Please ask for: Nicola Moore
Email: nicola.moore@arun.gov.uk
Telephone: Ext 37944
Our Ref: BR/5/22/T
Your Ref:
Date: 24th January 2022

Application for Works to Trees(s) subject to a Tree Preservation Order(TPO)

Development: 1 No. Sweet Chestnut (T1) - cut back from conservatory by 2m.
1 No. Acer (T2) - reduce from 8.5m to 7m.
Location: 36-37 Servite Close Bognor Regis PO21 2DE

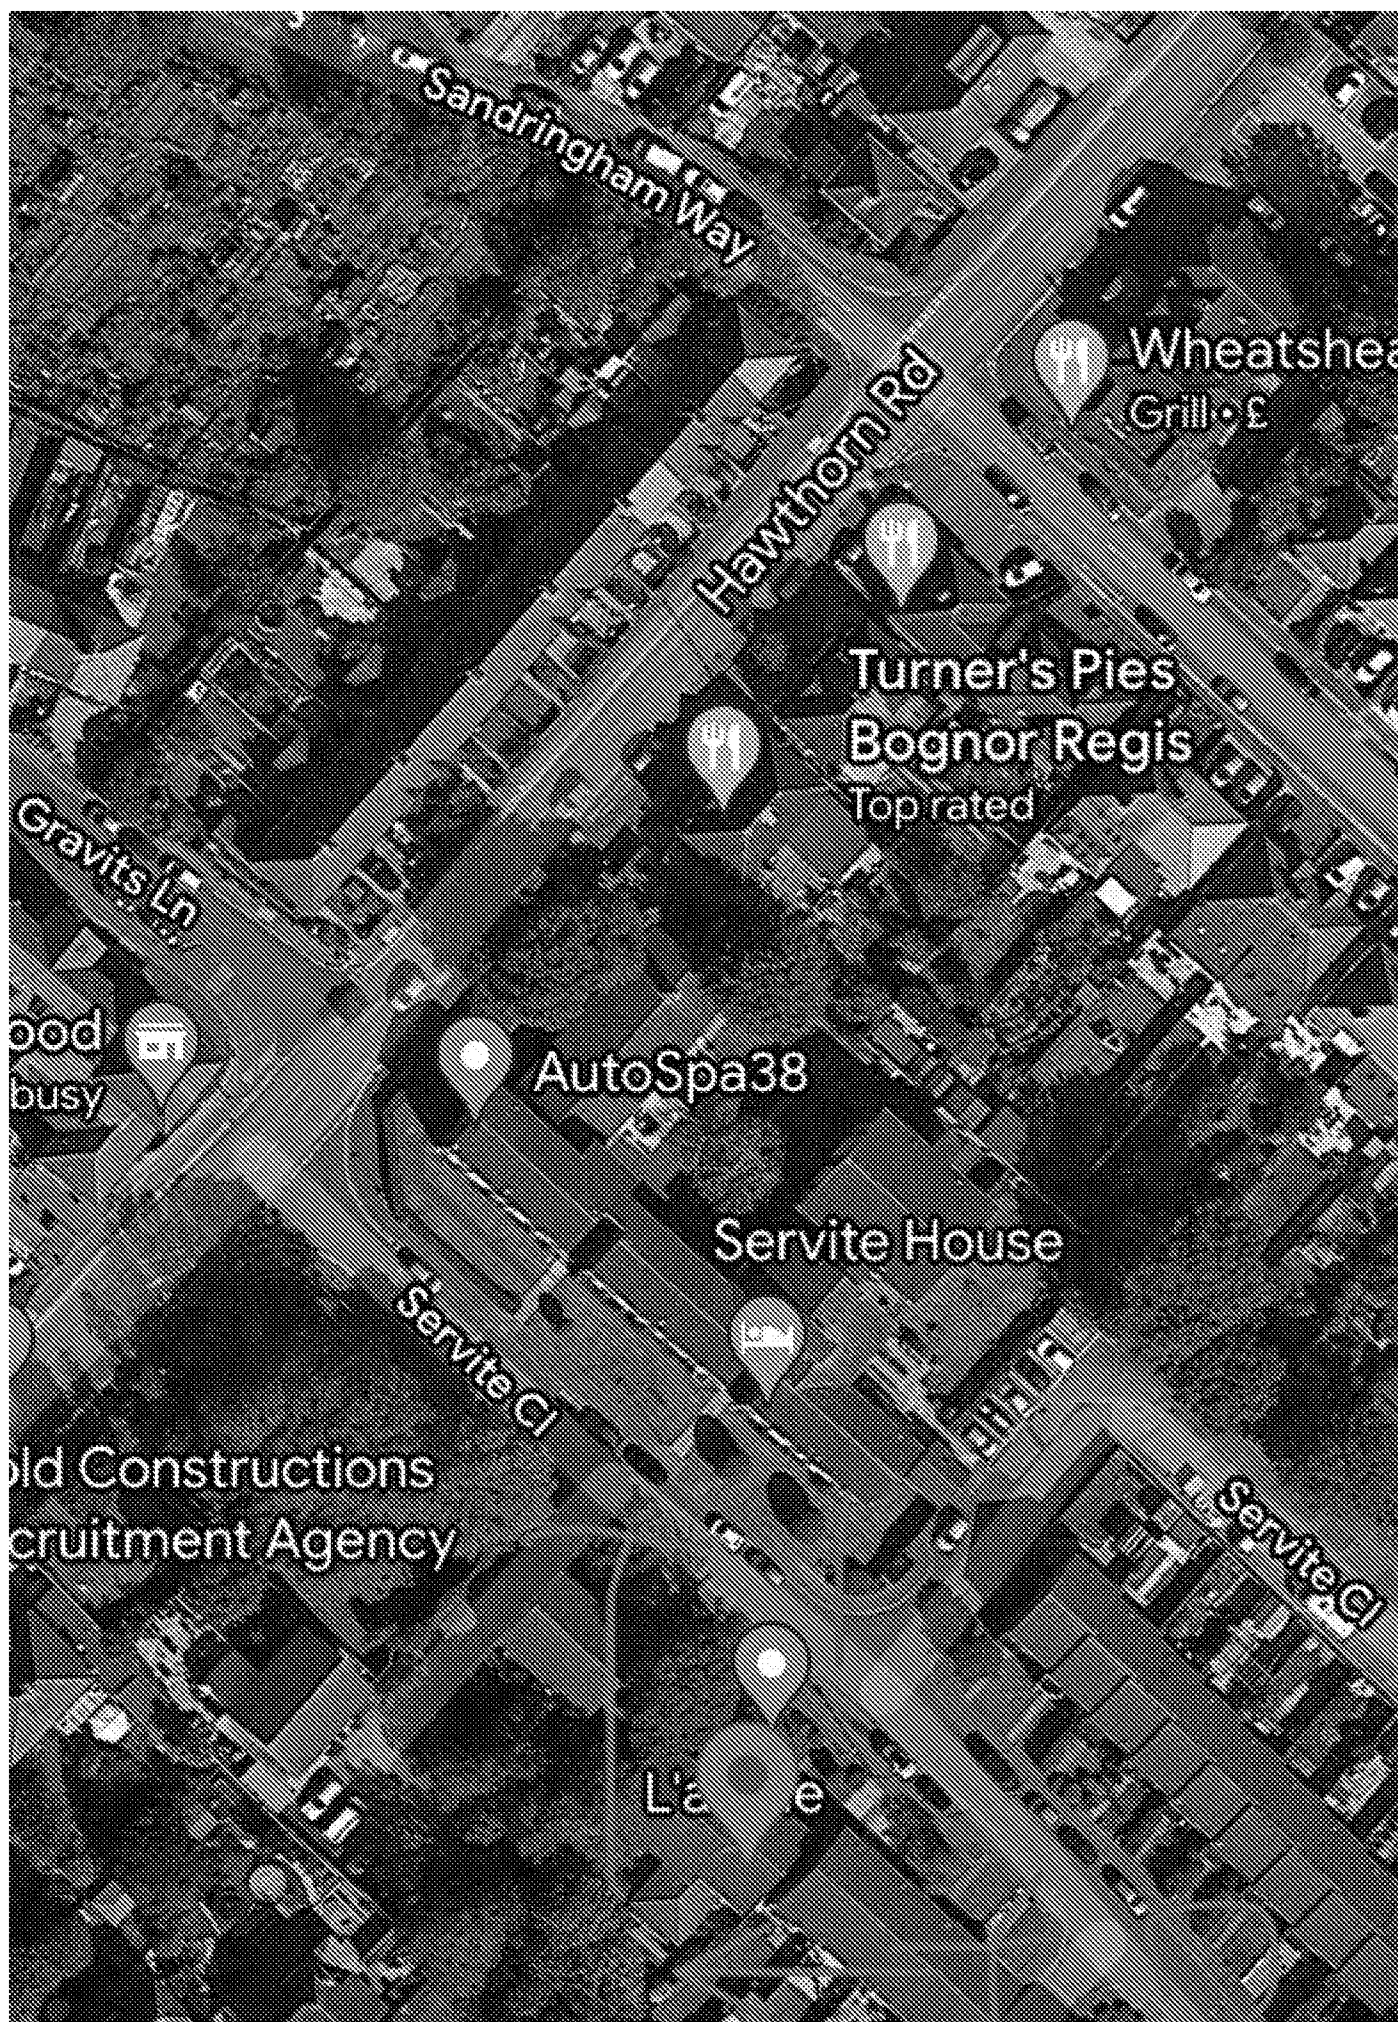
- 1 No. Acer tree - for clarity please confirm if 7m is the proposed height after the reduction. Please also provide the proposed spread measurement.
- 1 No. Sweet Chestnut - please provide the proposed spread measurement, in metres.
